**SSD\_7054: LEES 1 BUILDING AND SSD\_7055: F23 ADMINISTRATION BUILDING**  
**UNIVERSITY OF SYDNEY RESPONSE TO SUBMISSIONS**

The University of Sydney has reviewed all submissions received during the statutory public exhibition period of State Significant Application *SSD 7054 – F07 LEES 1 Building* and the *SSD 7055 – F23 Administrative Building*, both located on the southern edge of the University's Camperdown campus fronting City Road.

DRAWING NUMBER	REVISION
F23-A-DA-0205	0

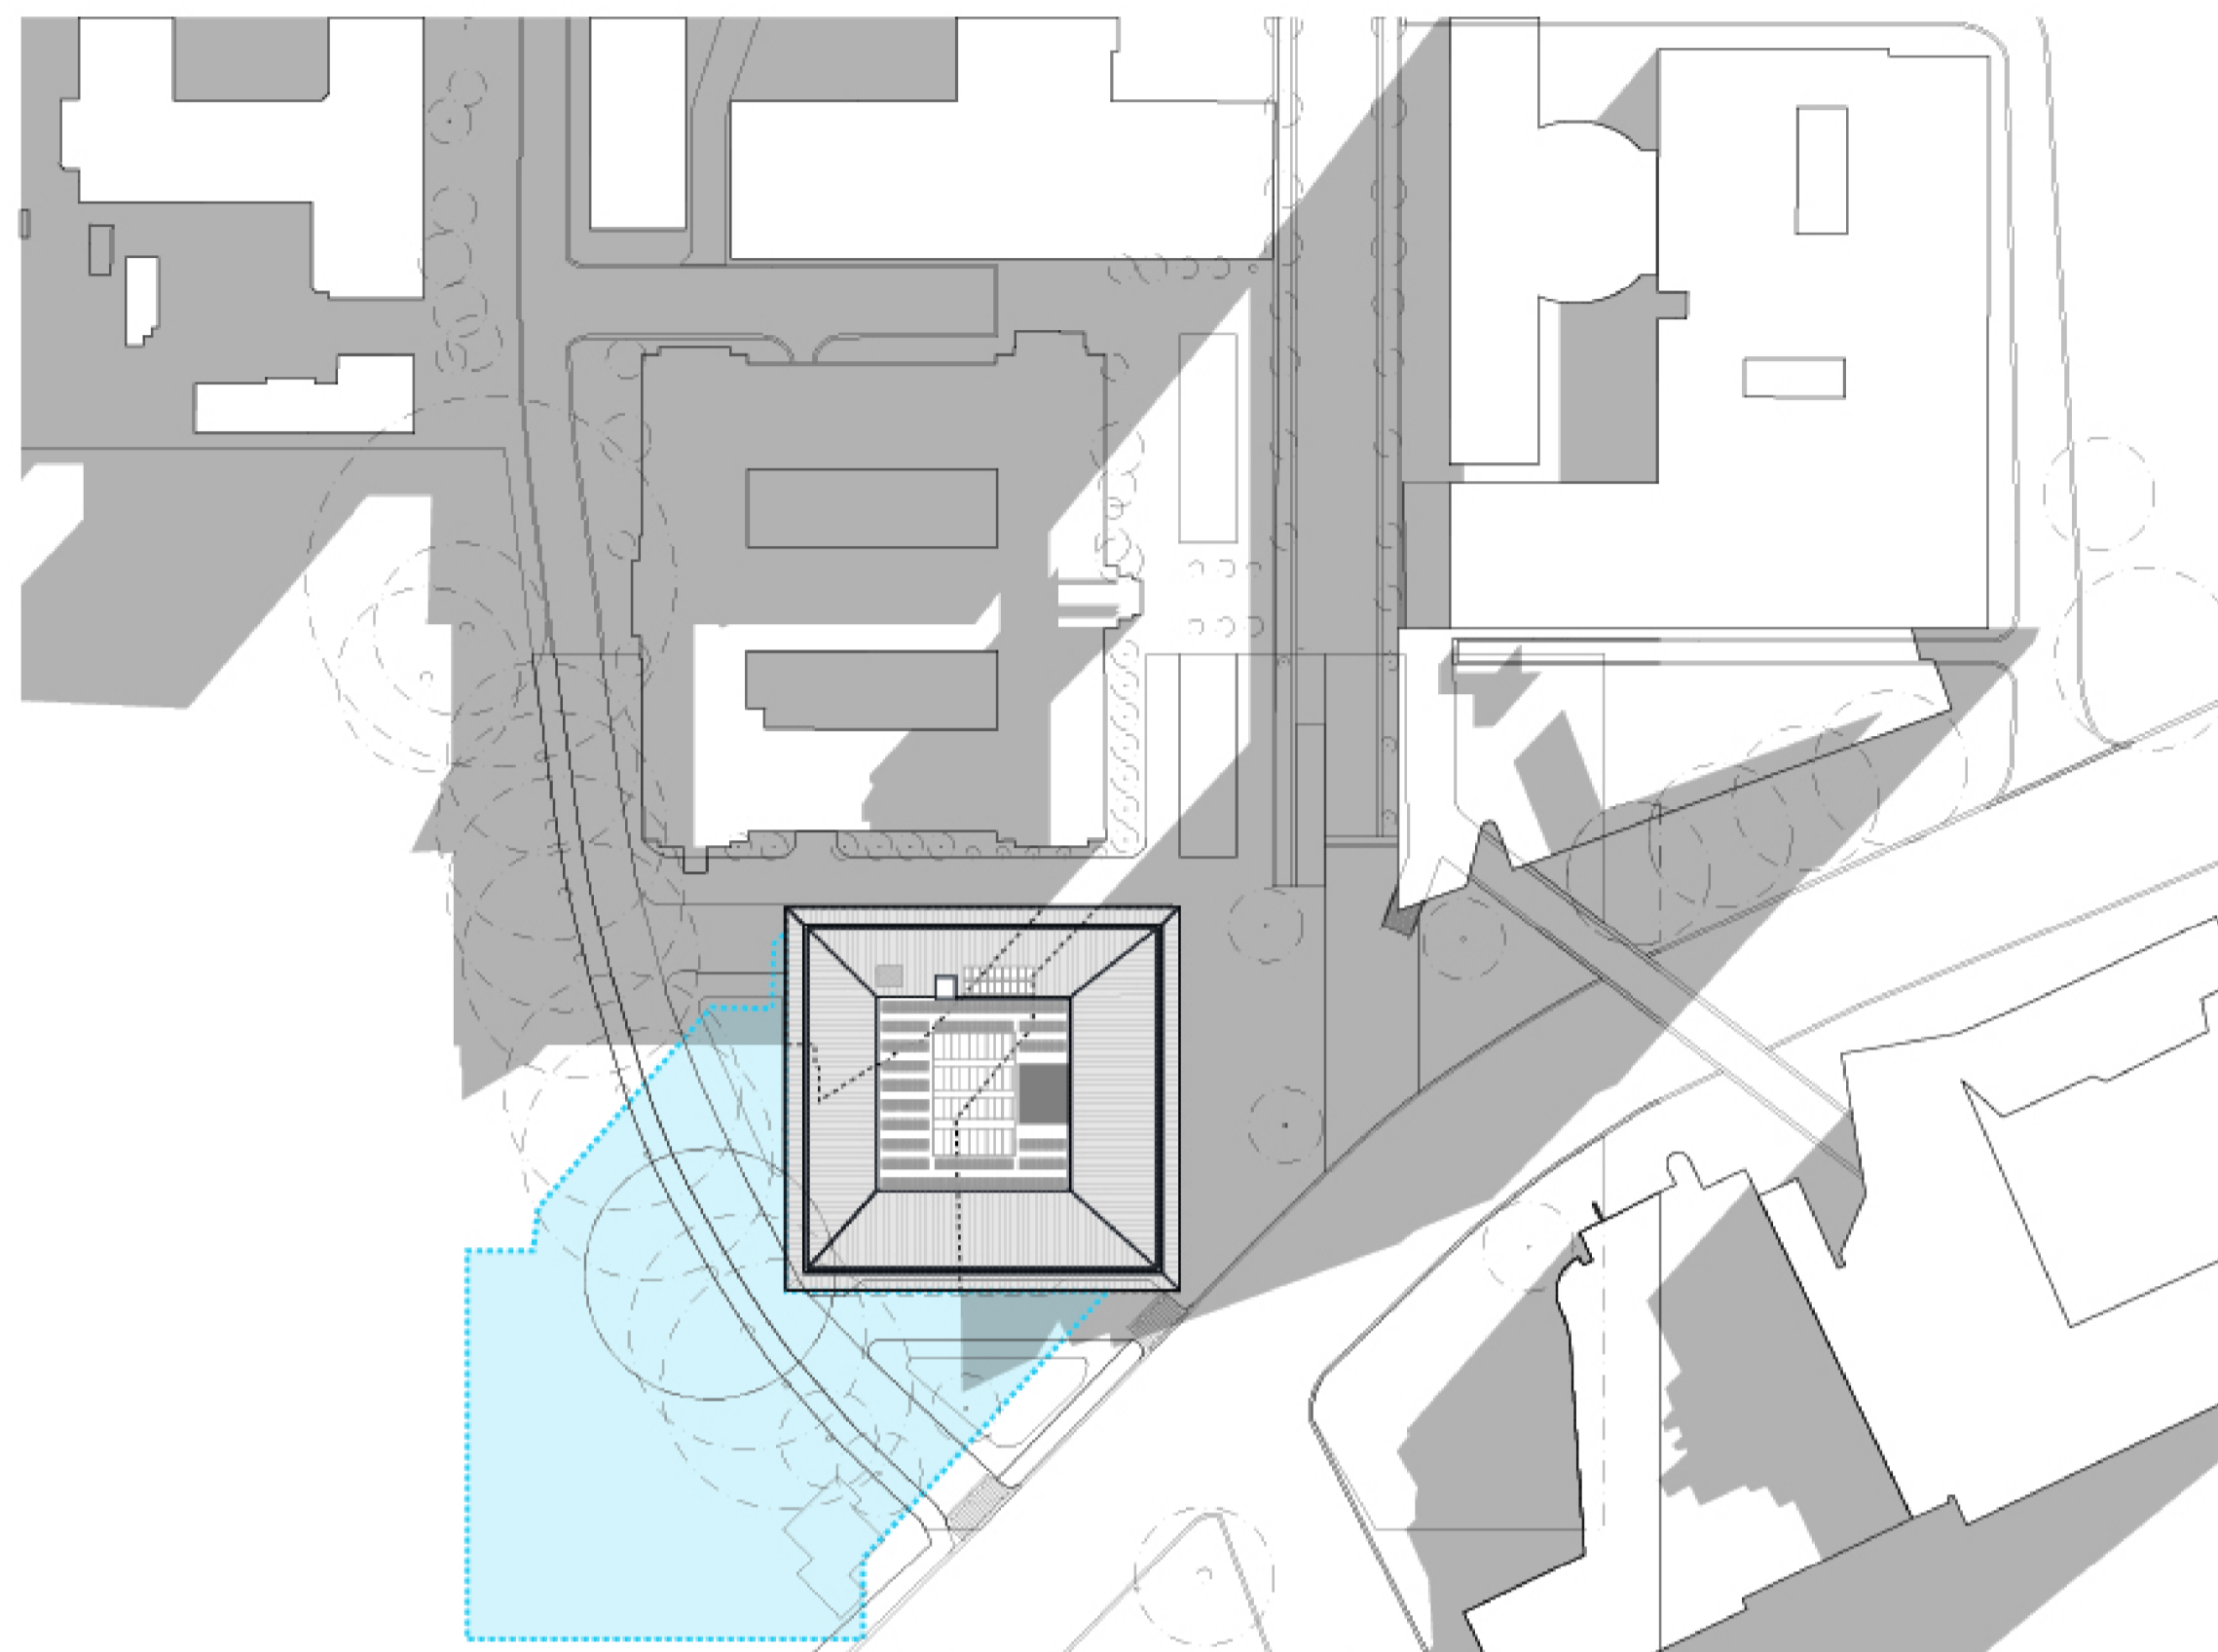
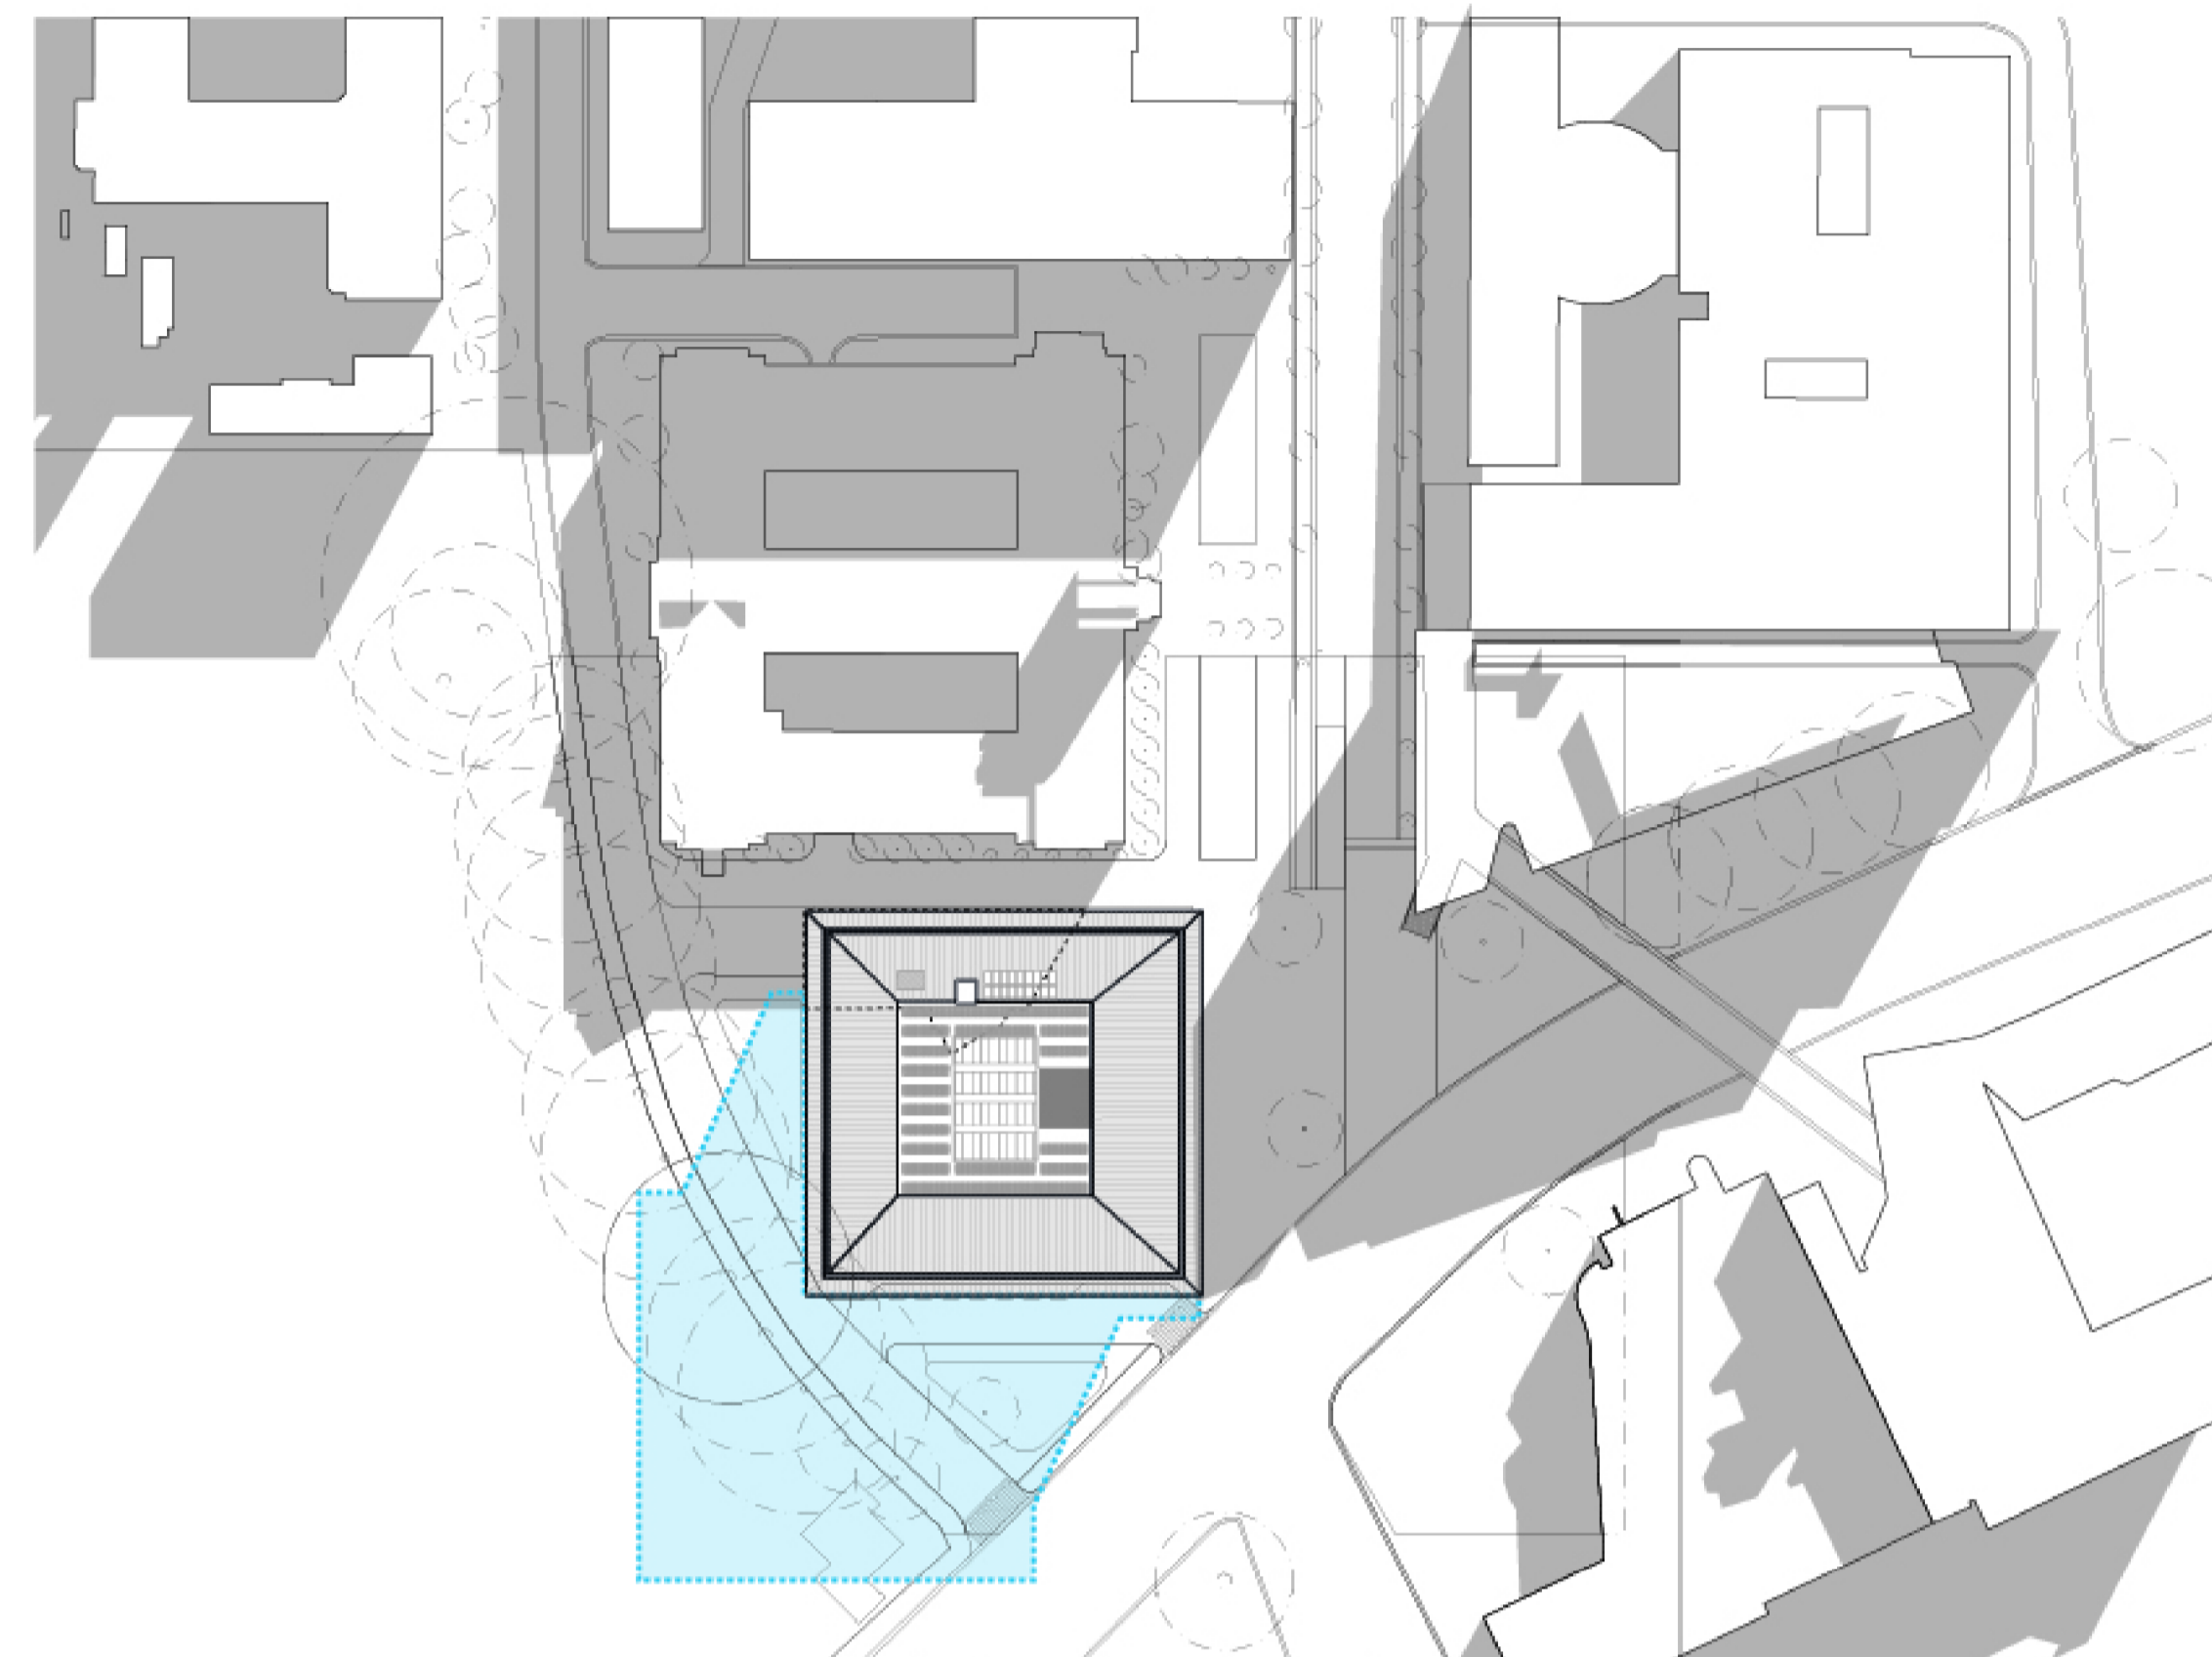
<p><b>8. Overshadowing</b></p> <p>Detailed diagrams are required to differentiate the existing shadow from that of the shadows cast by the proposal.</p>	<p>Amended shadow diagrams have been updated and included in <b>Appendix 01.03</b>.</p>
<p><b>9. Flooding</b></p> <p>The site is subject to flooding. The recommended finished floor levels specified in the Flood Report must be applied to the proposed development and thus comply with the City of Sydney Interim Floodplain Management Policy.</p> <p>As there are a number of stormwater upgrades proposed, a stormwater quality assessment should be provided in accordance with the Sydney DCP 2012 requirements.</p>	<p>Flood levels have been provided as per the civil stormwater report dated 16 March 2016.</p> <p>The finished floor levels are required to be 500mm above the levels as specified i.e. FFL 35.70 (proposed FFL 35.75) at entrances’ to the western side, and FFL31.80 (proposed FFL 32.10) on the eastern (Barff Rd) side, thus complies with the City of Sydney’s Interim Floodplain Management Policy. Refer to the attached drawings indicating the proposed FFLs.</p> <p>With respect to the water quantity, since the issue of the report, the stormwater strategy has changed in that we are now discharging to the Council/ Sydney Water system in City Road rather than the University of Sydney’s downstream network. The University is required to comply with parameters that Sydney Water has sent is in terms of OSD volume (37m<sup>3</sup>).</p>
